## NE18: Natural England Comments on Cumulative Impact Assessment of Soils and Agricultural Land

**Chapter Reviewed: Volume 6.0: Environmental Statement [EN010159] Volume 2: Aspect Chapters Chapter 18: Cumulative Effects**

**Chapter Reviewed: Volume 6.0 Environmental Statement [EN010159] Volume 3: Technical Appendices Supporting ES Volume 2 Appendix 18.3 Summary of Other Developments included within the Cumulative BMV Assessment February 2025 Document Reference: EN010159/APP/6.21**

Drawn Date:
2025-01-27

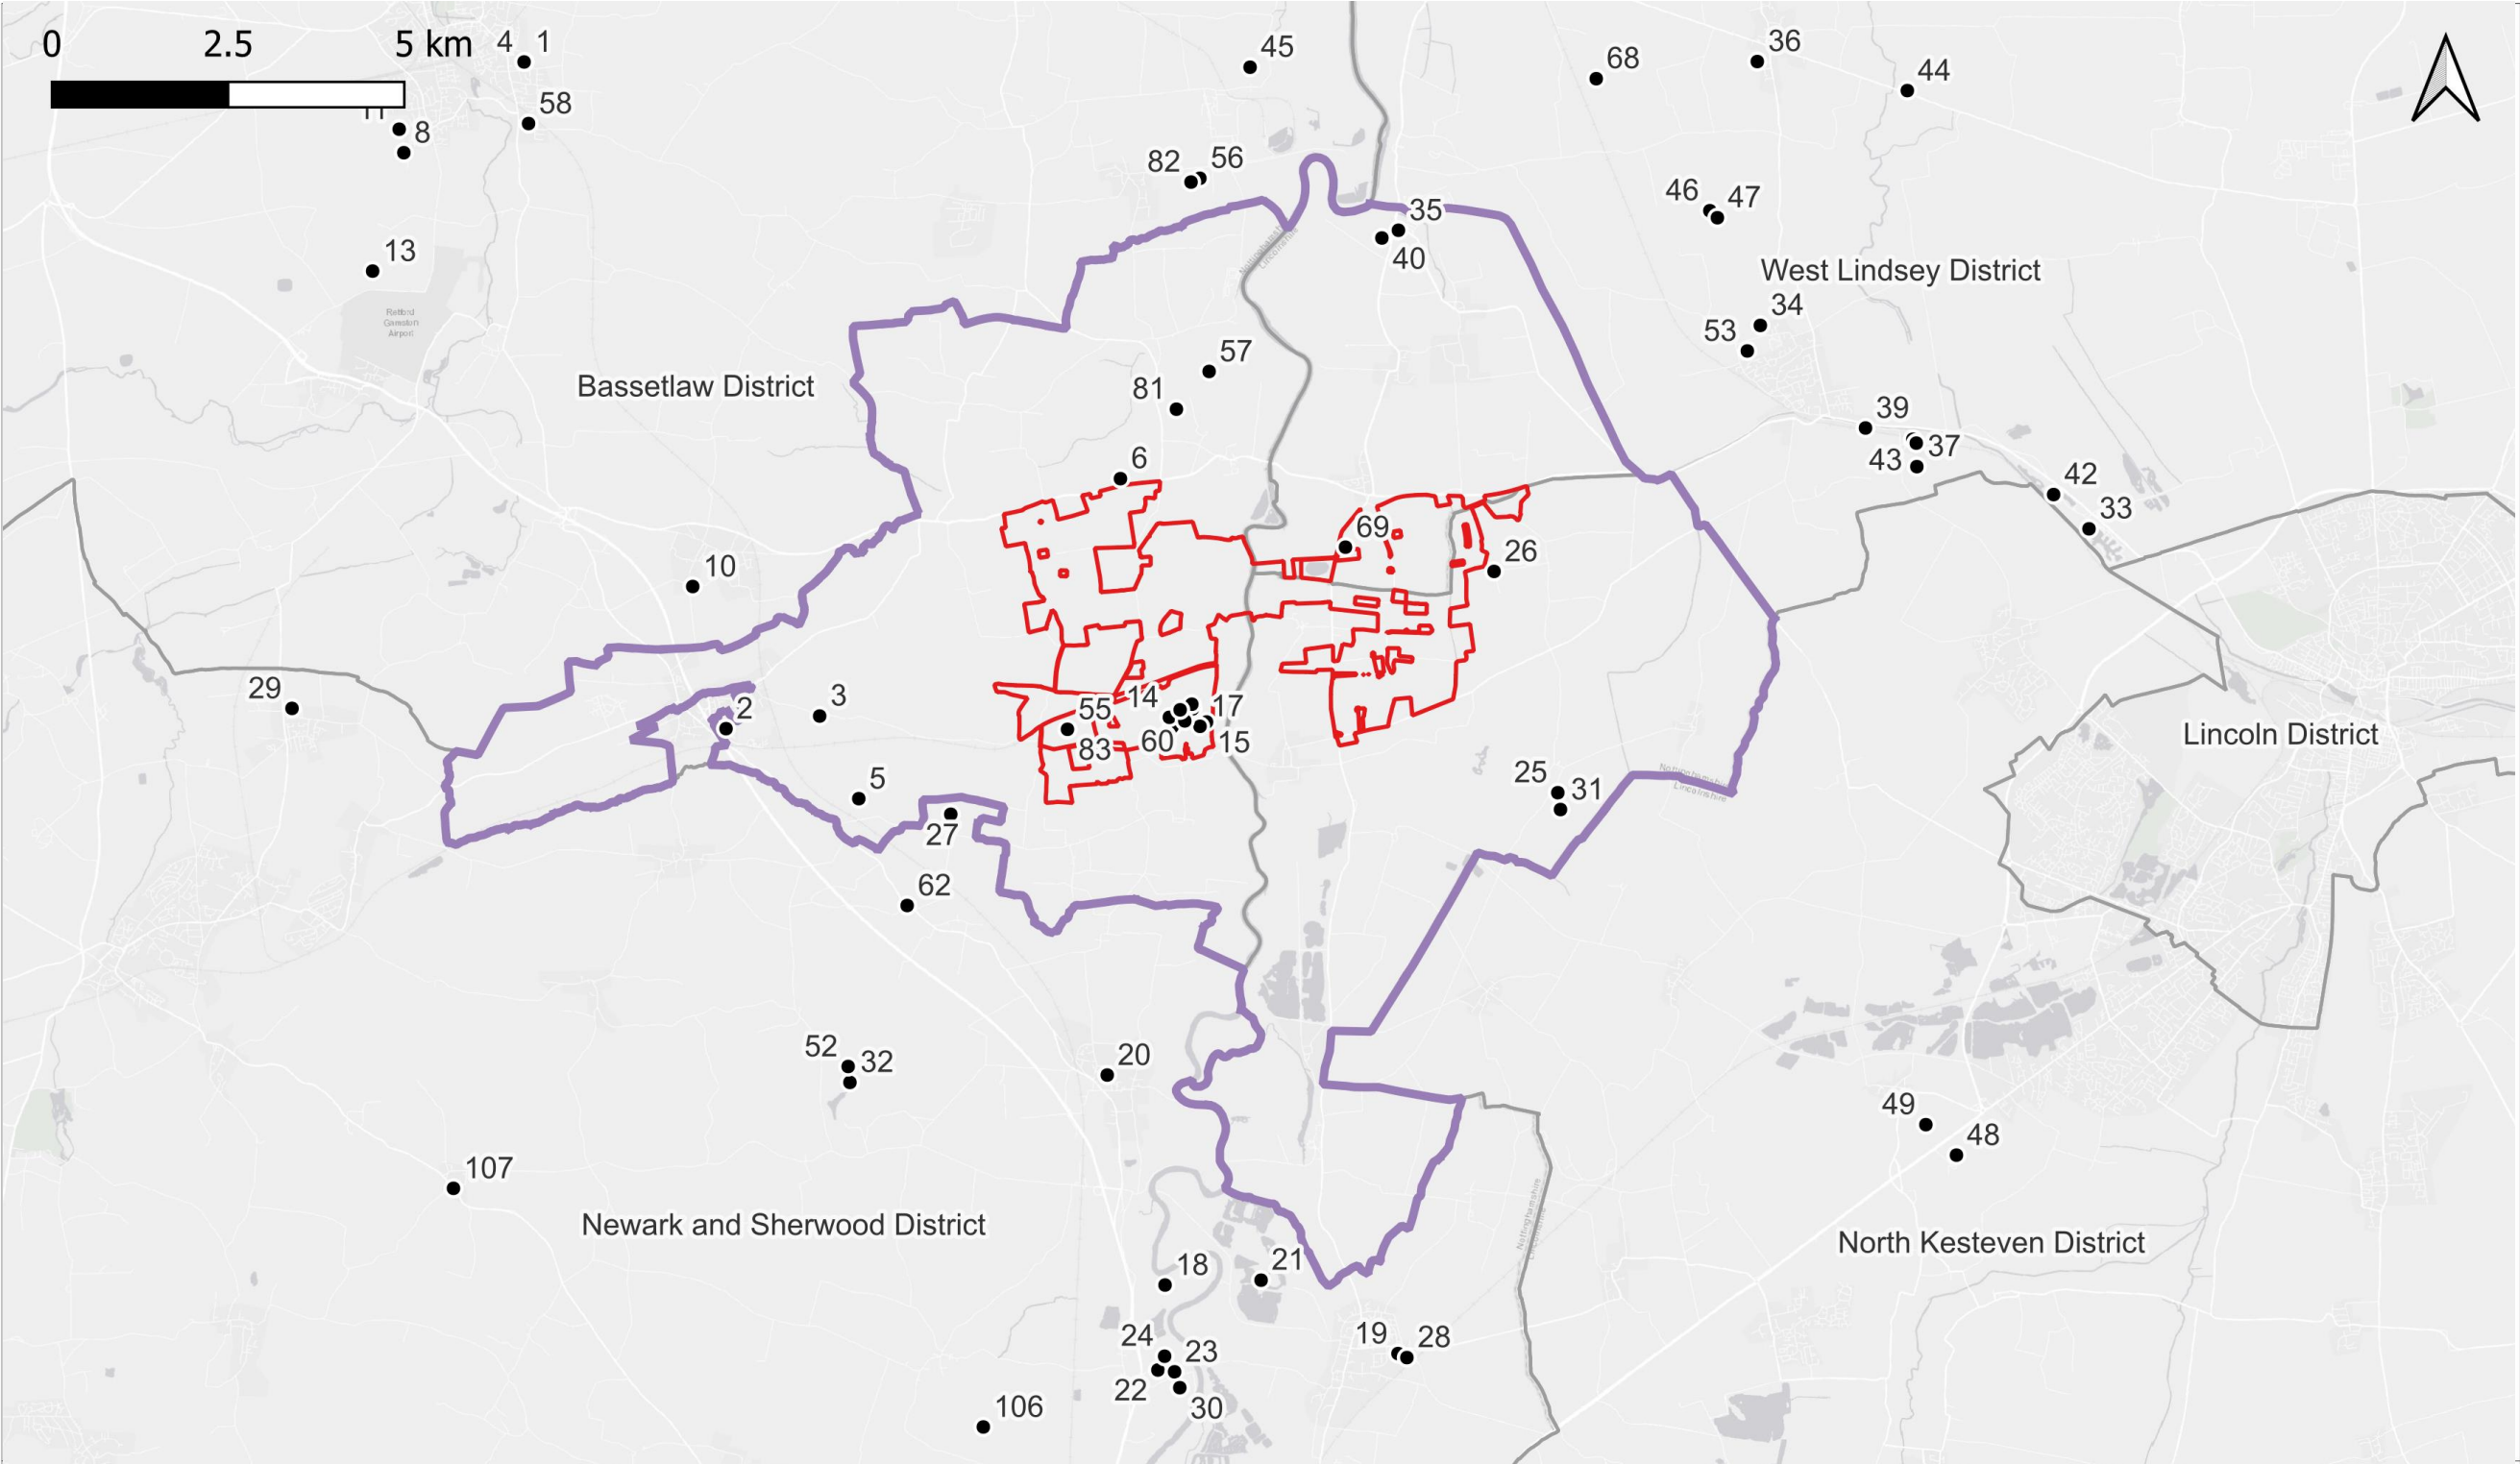
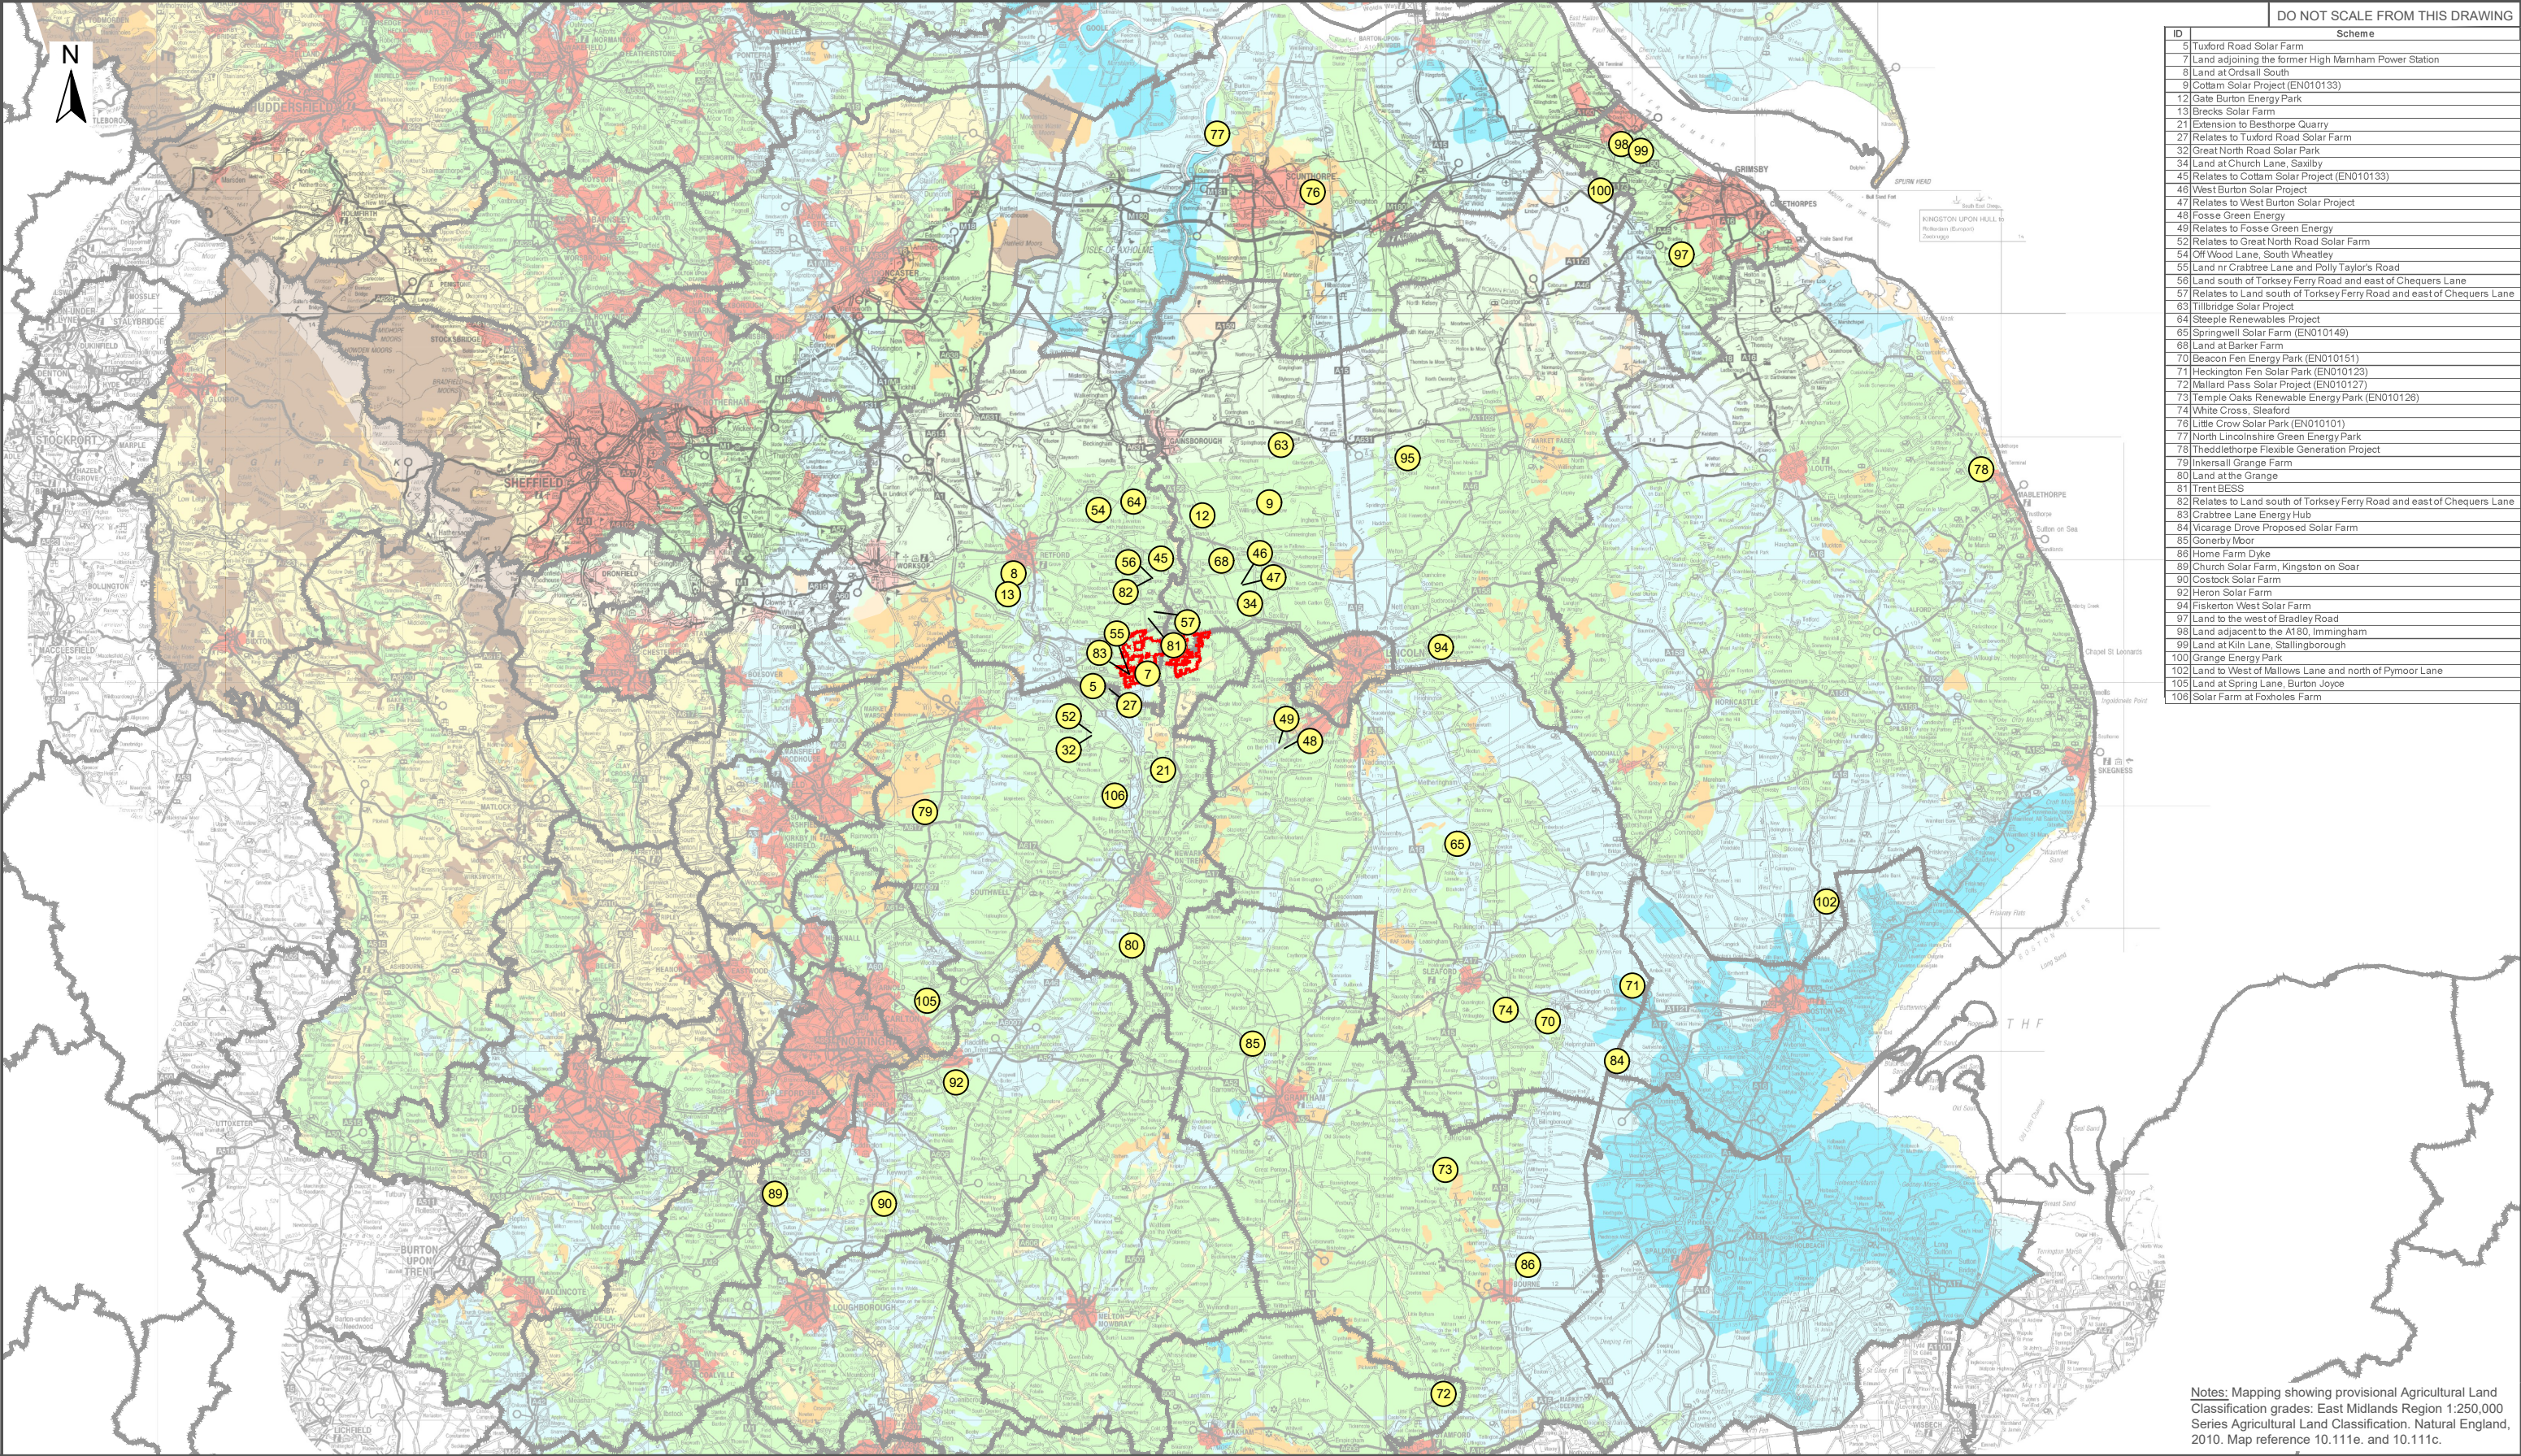
**18.3.19** Natural England are broadly satisfied with the regional Zol and the information provided within ES Volume 3, Figures 18.1 to 18.8 [EN010159/APP/6.20] for a regional cumulative assessment, however we refer the applicant back to the comment above (table 18.2)
